SUBJECT: Engineering Review Comment
Mountain View Electric Association Inc. (MVEA)

Project Name: Village at Lorson Ranch Filing 1 – Rezone and Final Plat

Project Numbers: CS242 and SF248

Description: A proposed Rezone and Commercial development of 6 lots and 1 tract located west of Marksheffel Rd. and Fontaine Blvd. to the south in Township 15S, Range 65W, Section 15

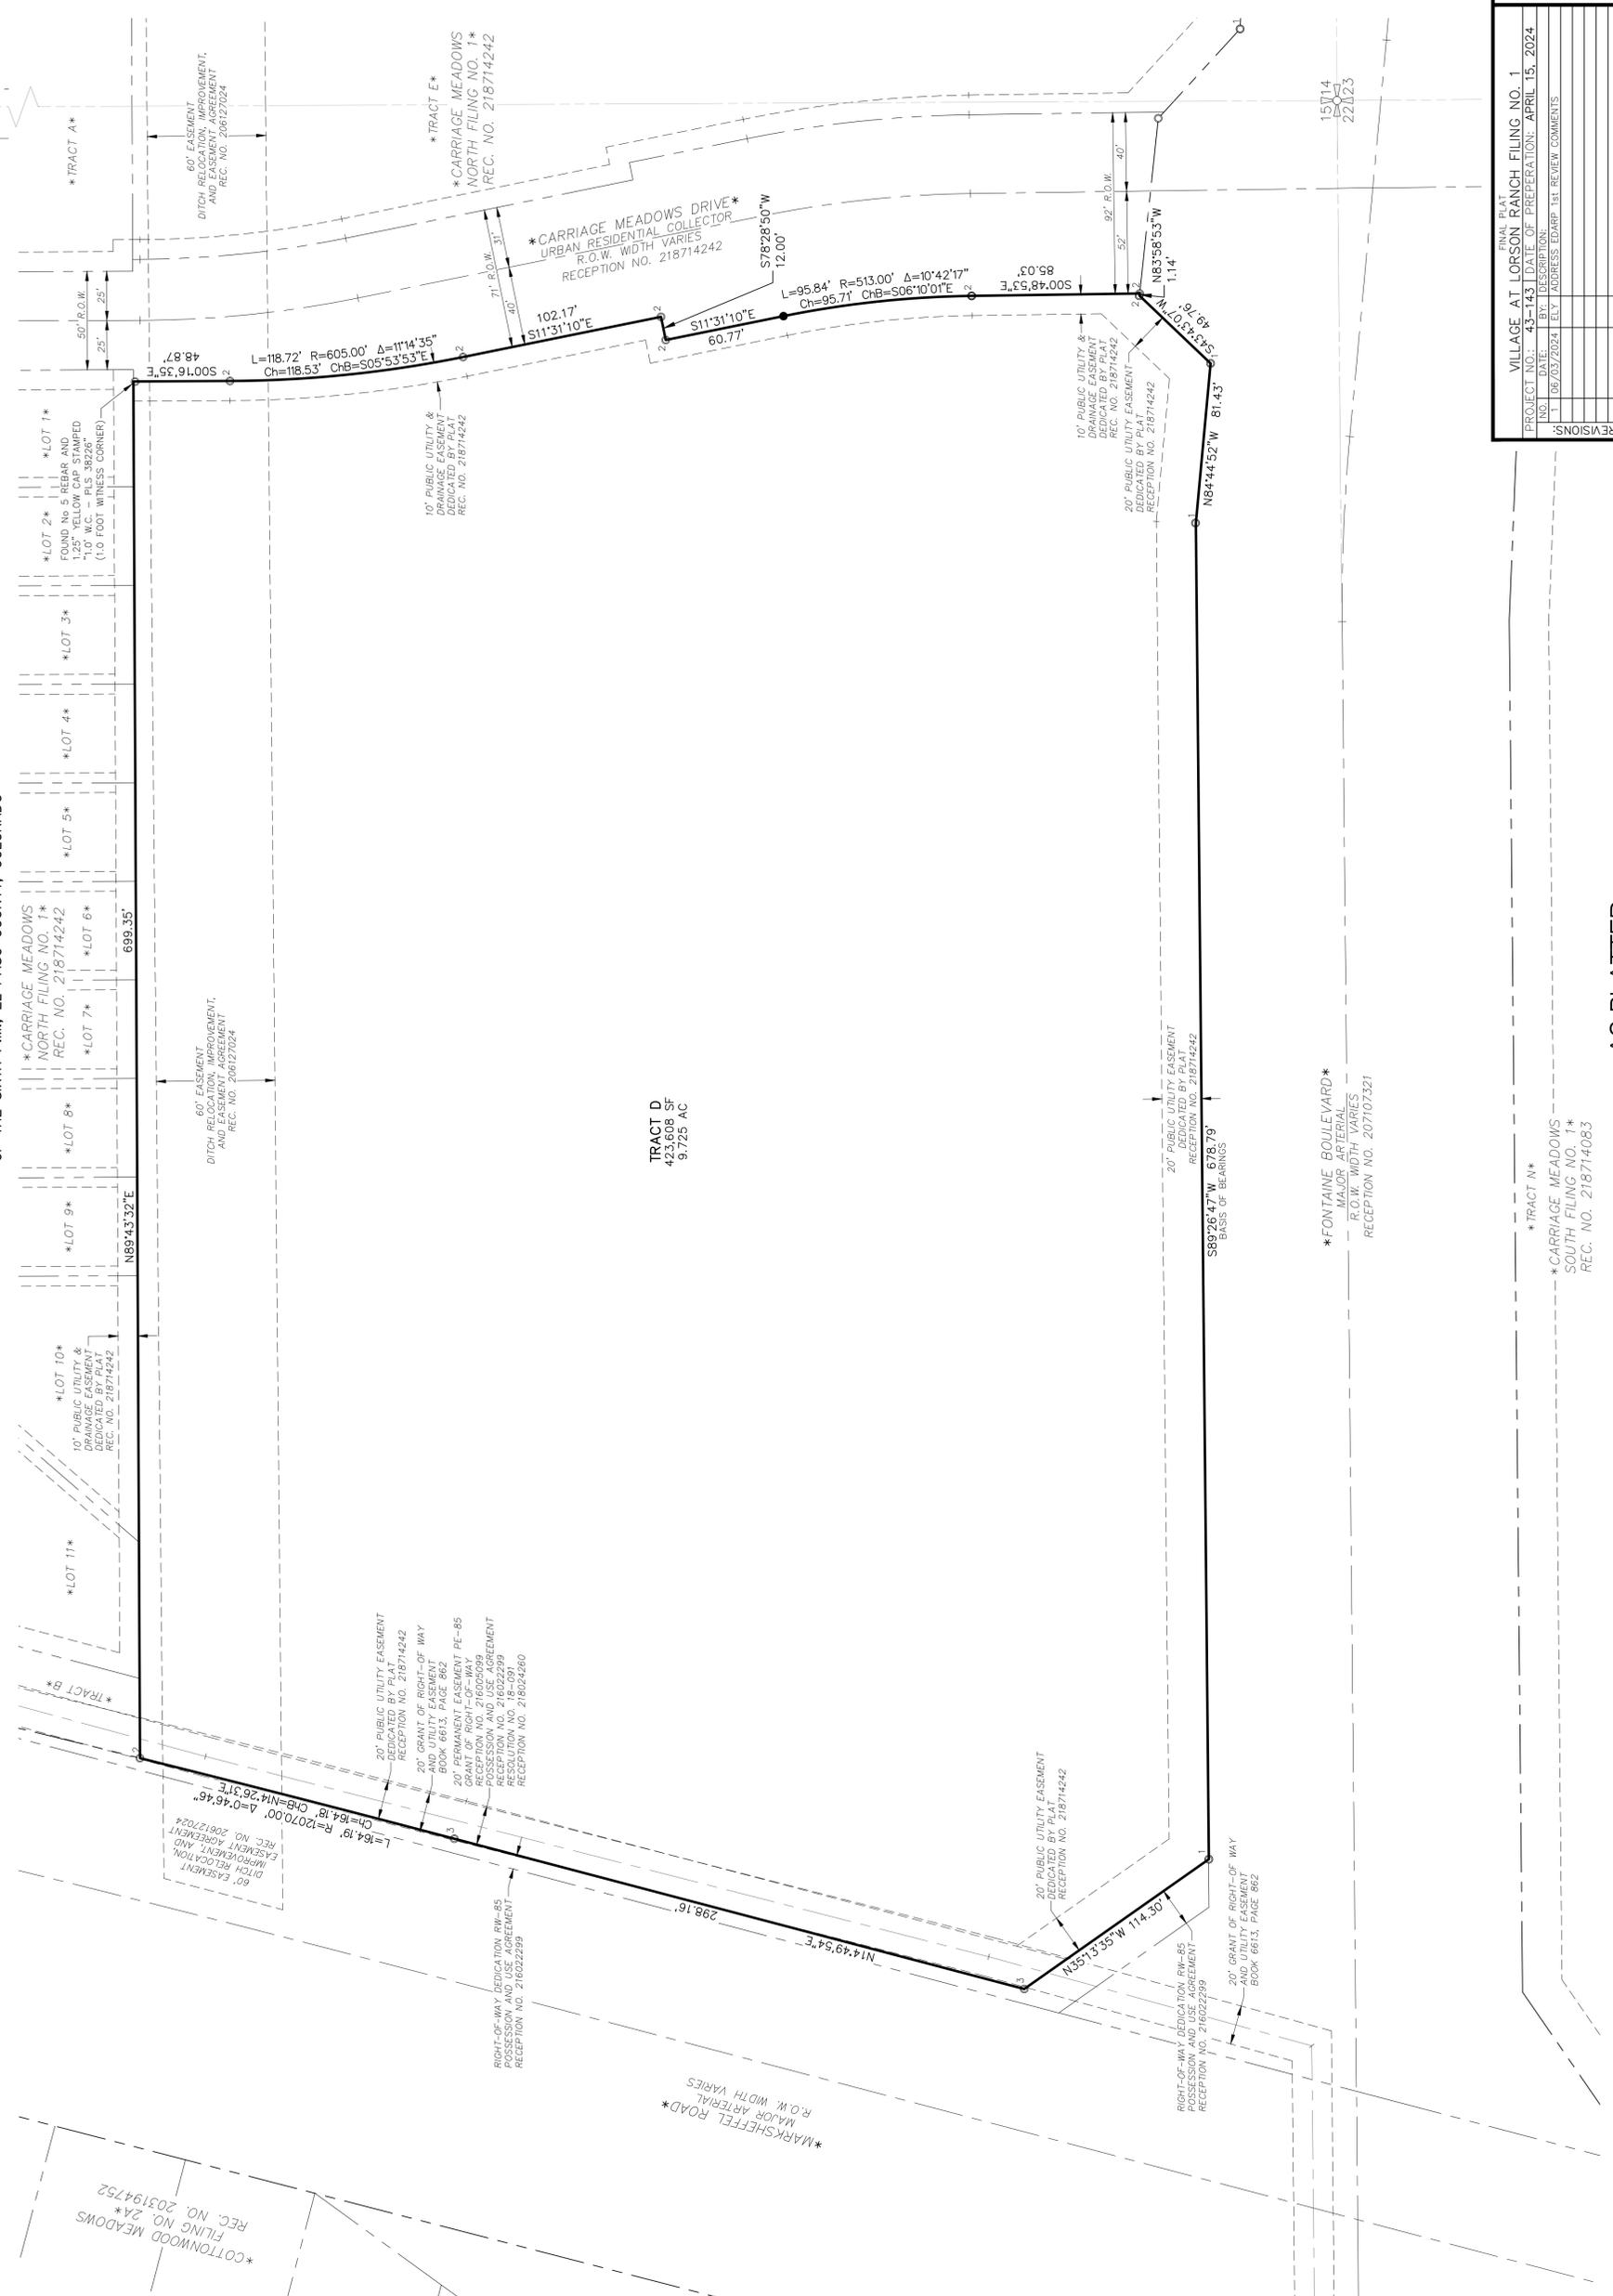
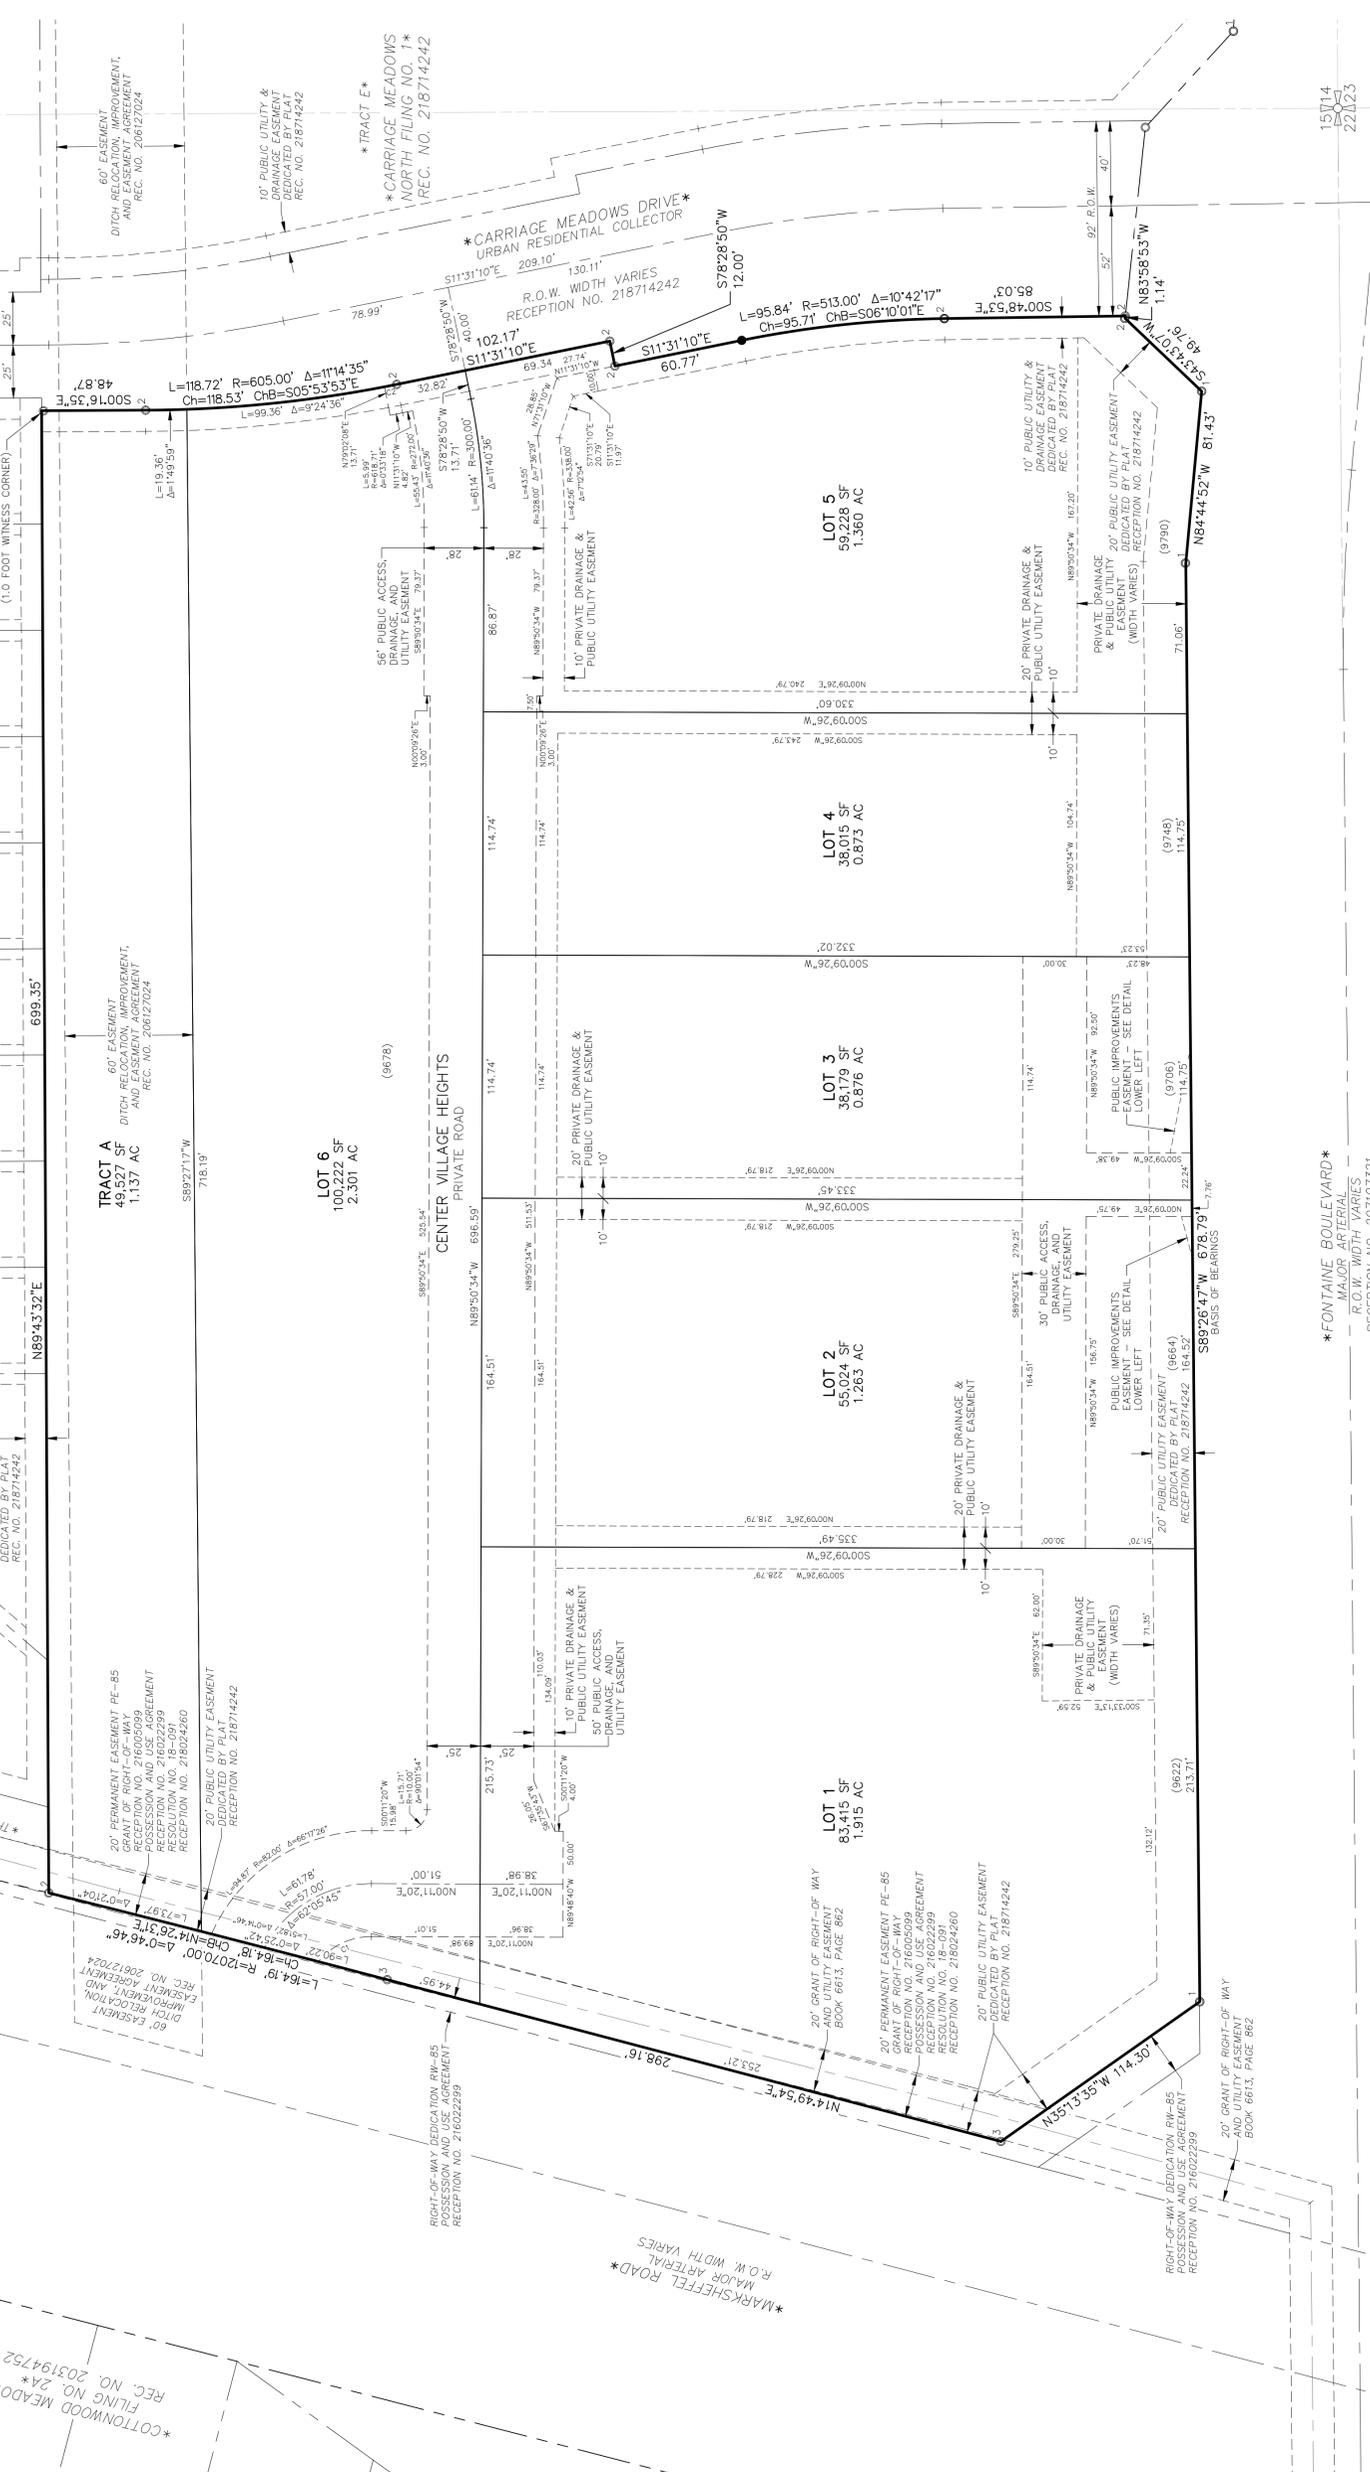
MVEA requests twenty (20) foot front, side, and rear utility easements on commercial lots and will work with the developer on the design of the electric service and to acquire any additional easements. MVEA also requests the platting of MVEA's existing facilities with easements on the plat.
